Department of Planning, Housing & Infrastructure

**Powerhouse Ultimo Renewal (SSD-67588459) | Response to City of Sydney
Correspondence Dated 01 October 2024**

Figure 32 Vehicle swept path analysis – loading dock

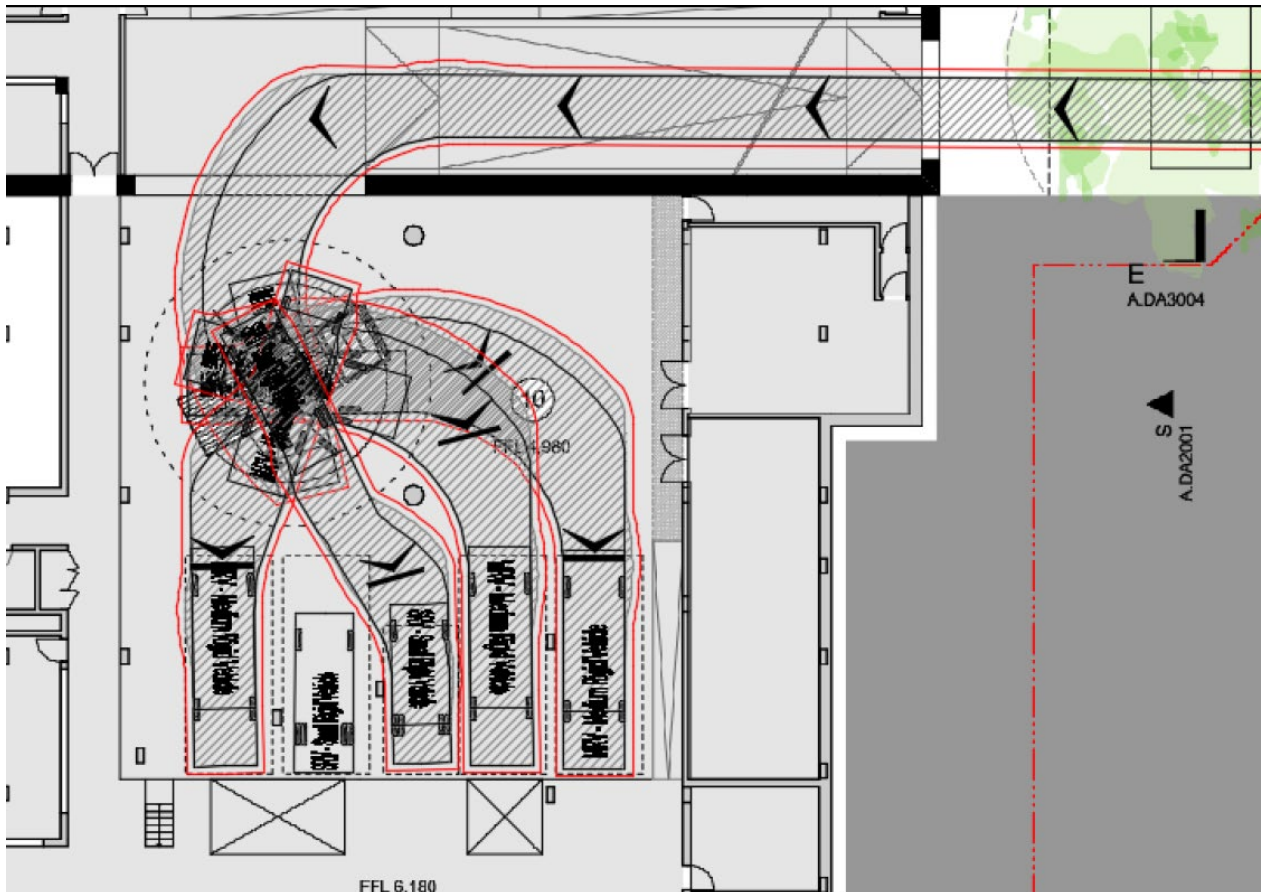
The vertical clearance check along Macarthur Street of the Amended Transport Assessment has been completed for an HRV, however, the maximum design vehicle is a semitrailer. It is recommended that the vertical clearance check along Macarthur Street be completed for a semitrailer to confirm no vehicle scraping.

A vertical clearance check for a 19m semi-trailer on Macarthur Street has been undertaken and confirms the road design is suitable to accommodate this vehicle type. This vertical clearance check is provided in Appendix A of this document.
